Our Ref: ID 3316
Your Ref: SSD-65595459

State Significant Development Application for Indoor Sports Centre (HISC)

We refer to our previous response dated 11 November 2024, with reference ID2728, including the key considerations relating to emergency management. We provide further advice below, based on our review of the proposed amendments and updated project documentation.

4-4

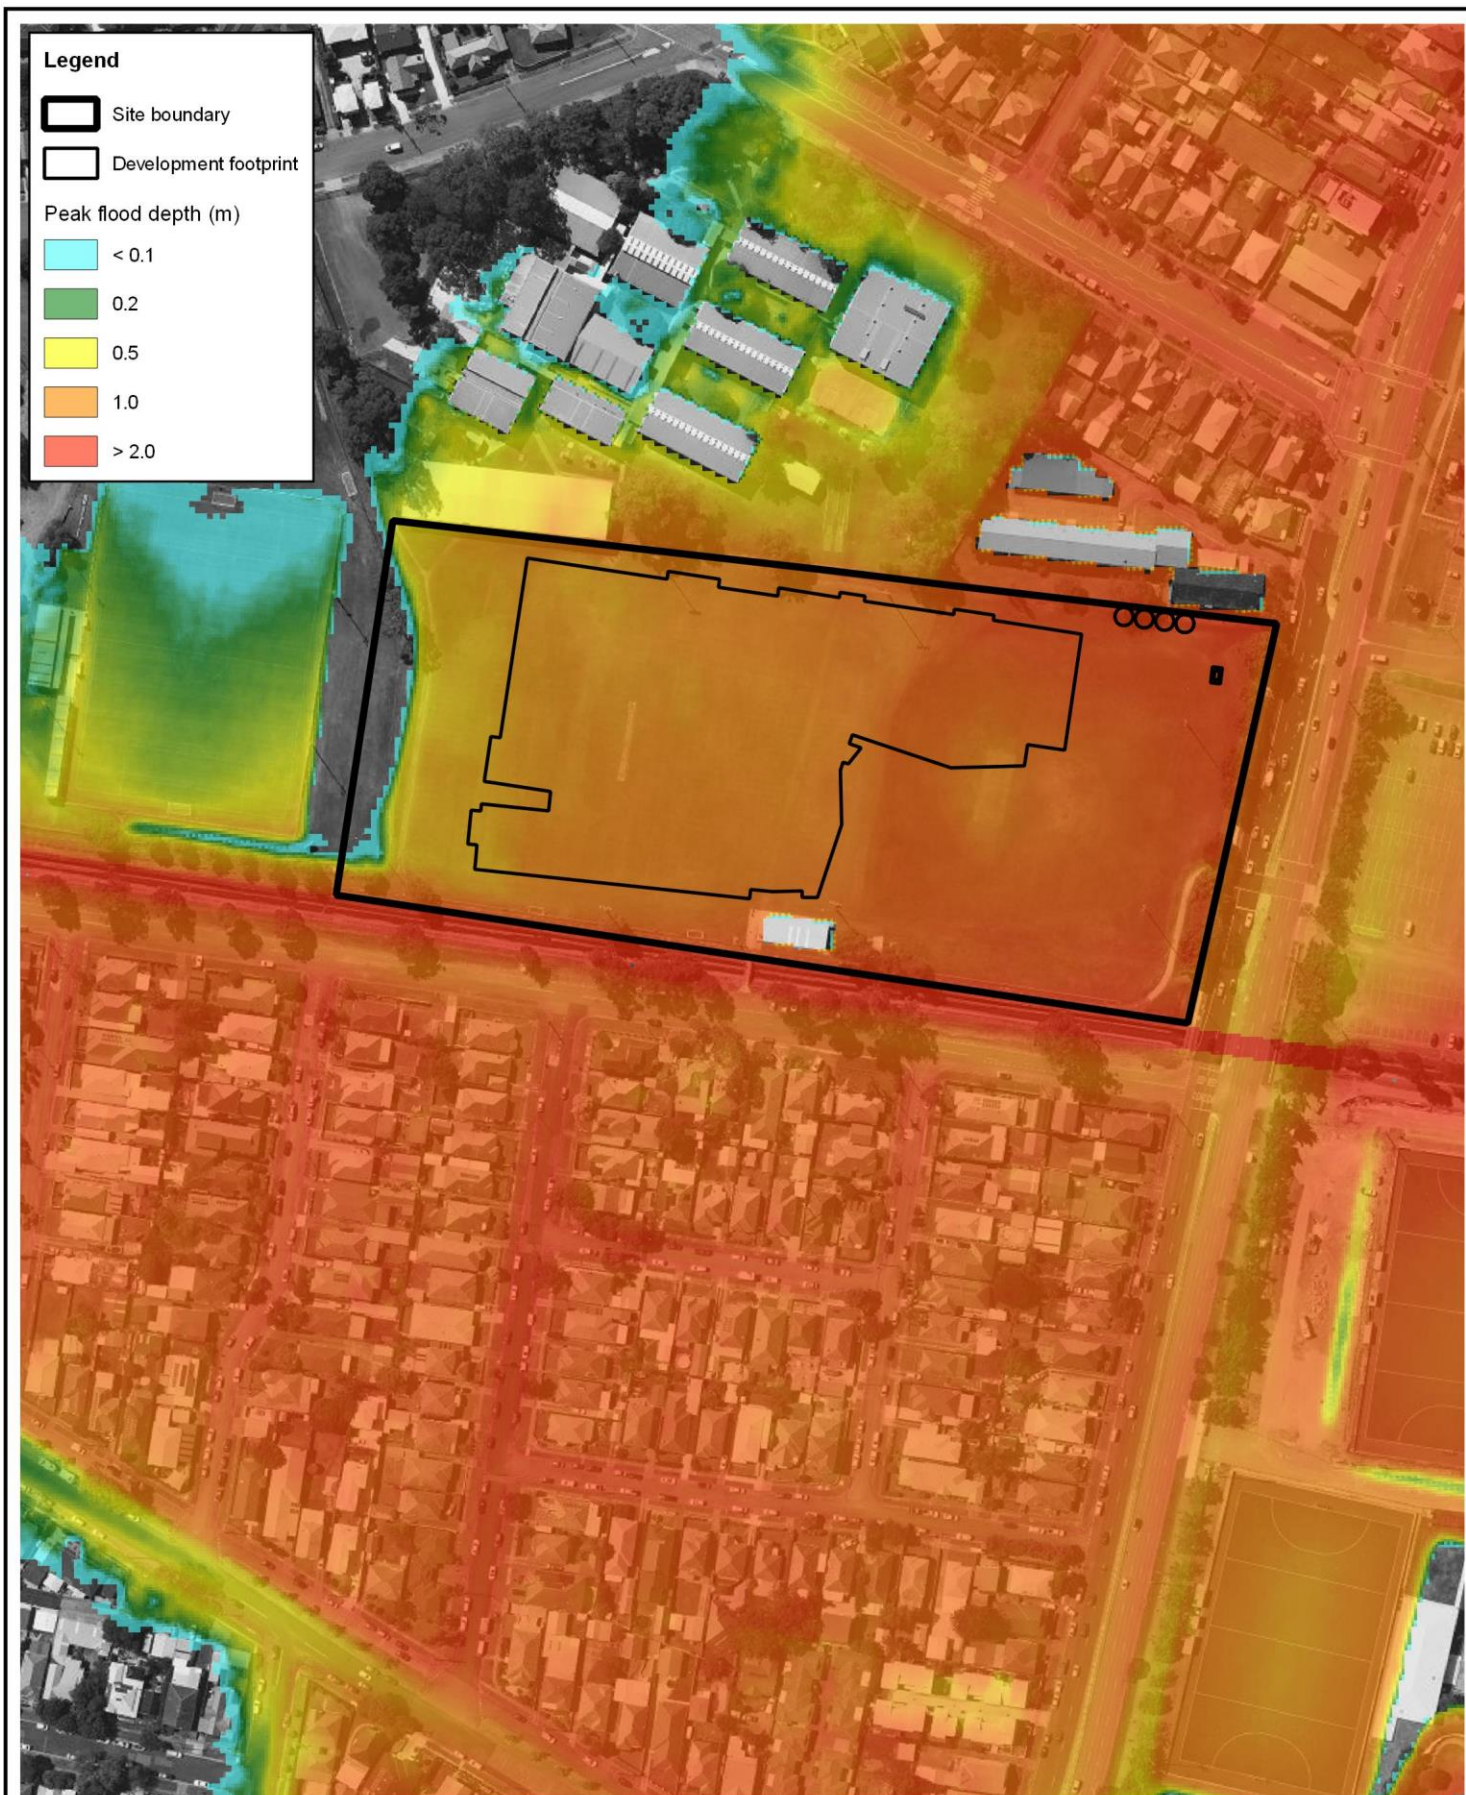
In existing conditions, a small part in the northeastern corner of the site becomes impacted by flooding (less than 0.2 metres peak) as frequently as 10% Annual Exceedance Probability (AEP) events,⁴ however, site vehicular access (onto Turton Road) would be cut in these frequent events, and therefore access/egress and evacuation would be restricted.⁵

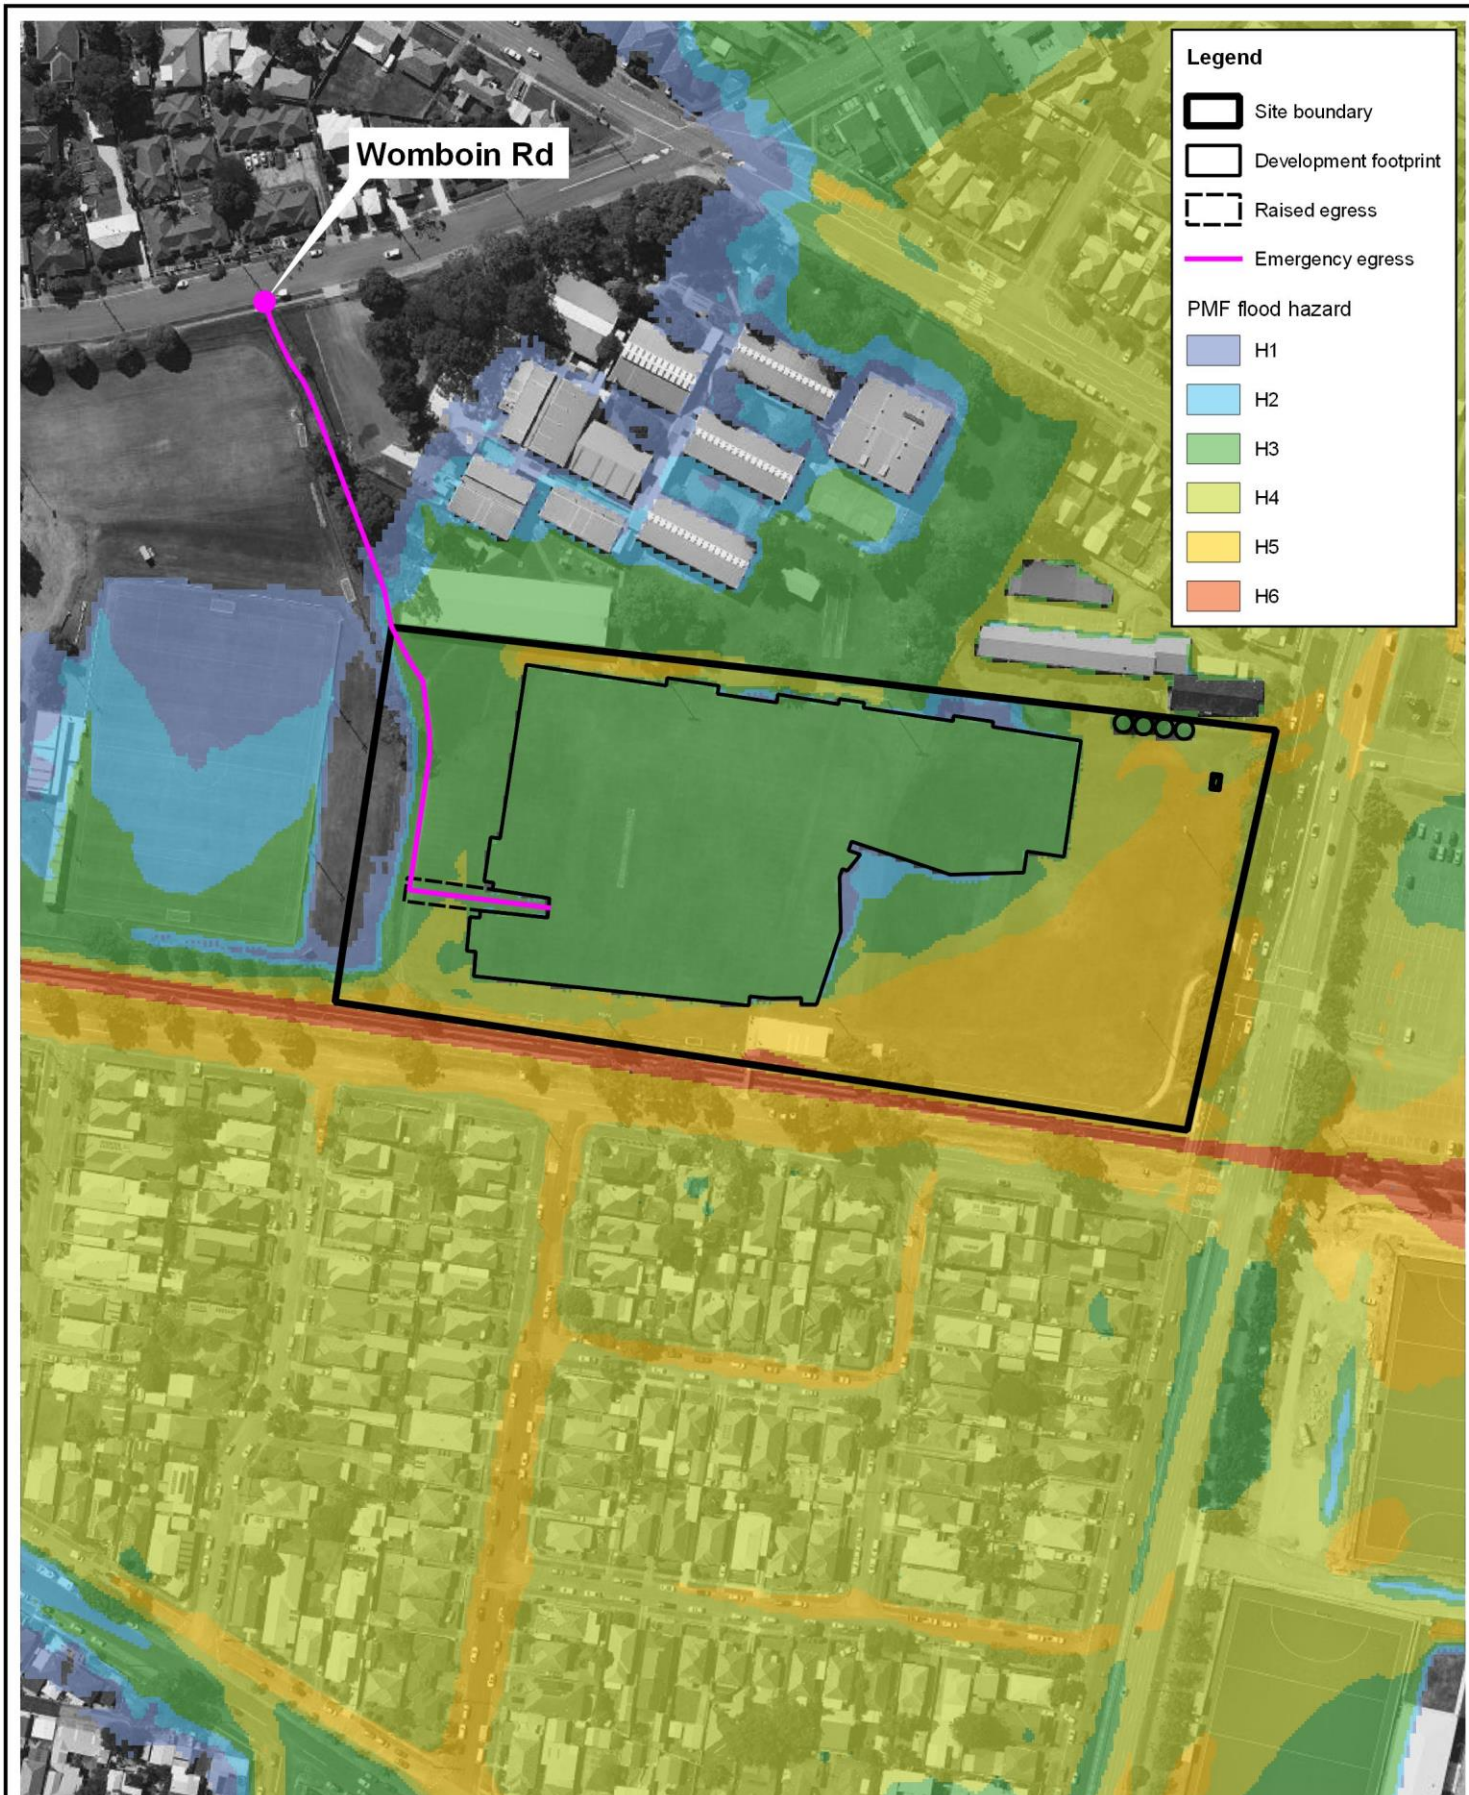
- **Recommend** considering site design to avoid entry or exit through high hazard areas (such as the Turton Road exit).
- **Recommend** investigating alternative site design options that may provide vehicular access northwest to Womboin Road, *if feasible*, noting that currently this is the proposed pedestrian emergency access – which appears to remain flood free up to and including the 0.2% AEP events and provides rising road access,¹ thus providing improved flood resilience compared to the Turton Road access.

- **Recommend** removing any reference to people wading through floodwater from the FERP³. Evacuation must not require people to drive or walk through flood water.

The FERP also implies it is safe to enter floodwater, “*Even during the peak conditions of a PMF event, **pedestrian egress from the Site would still be possible to Womboin Road, albeit by***

wading through medium hazard flood waters.”¹⁵ Floodwaters should not be entered, particularly by school children who are particularly vulnerable to the hydraulic hazards and potential debris and contaminants.

B-3

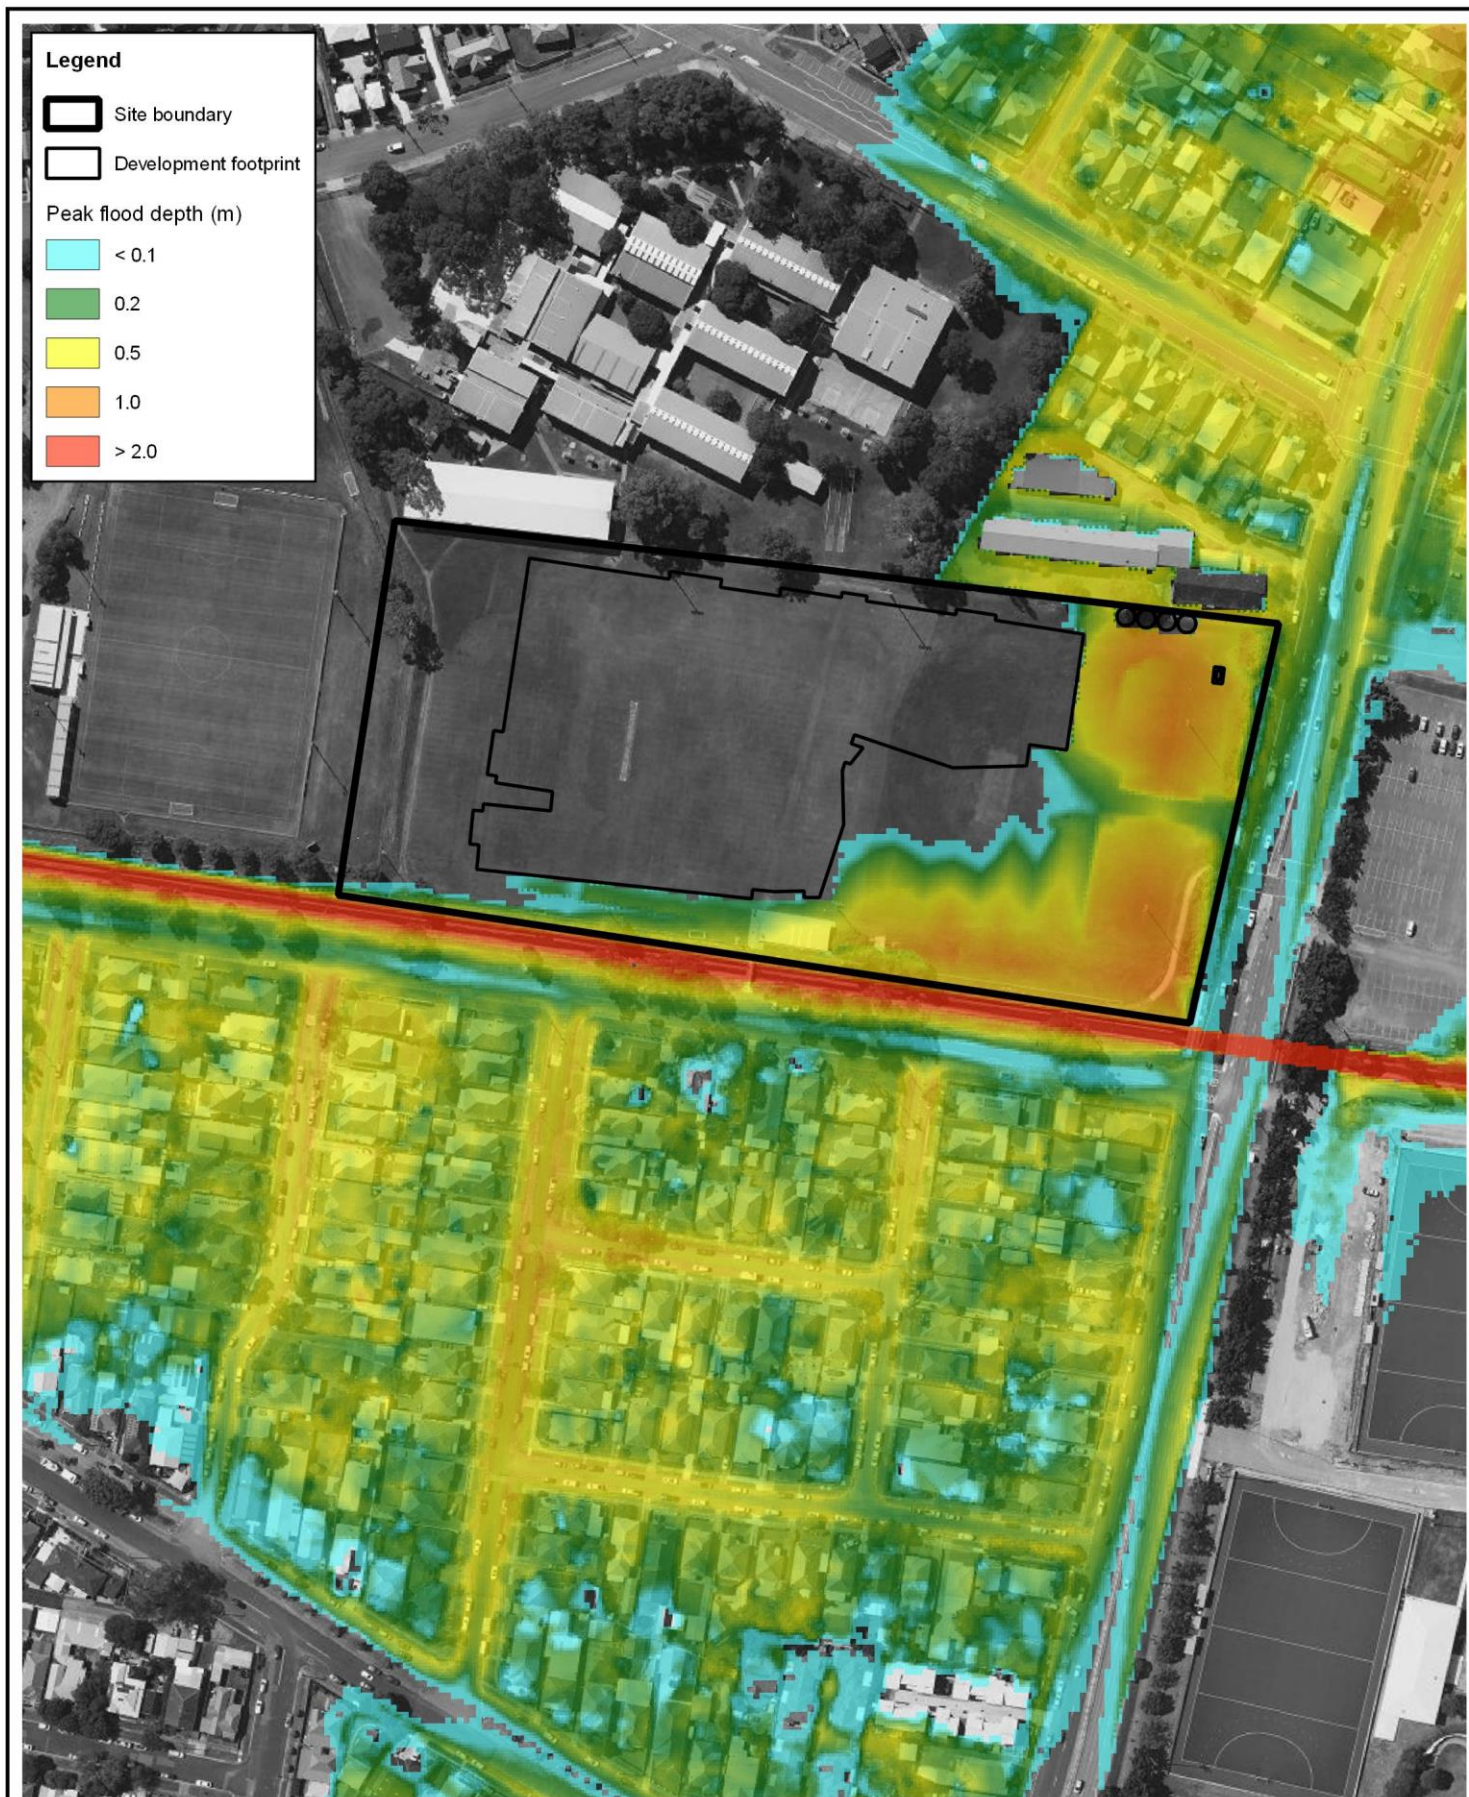
In a 1% AEP the eastern half of the site becomes inundated with flood depths peaking around 1 metre depth and H3 flood hazard level,⁶ with the higher flood depths and hazard level around its vehicular access/egress point. It is understood that in post-development conditions some of the flood flows are captured within the proposed swale (that can see flood depths in excess of 2 metres in a 1% AEP event⁷), however the site access/egress remains impacted by H3 hazard level flooding which is unsafe for people and vehicles.⁸
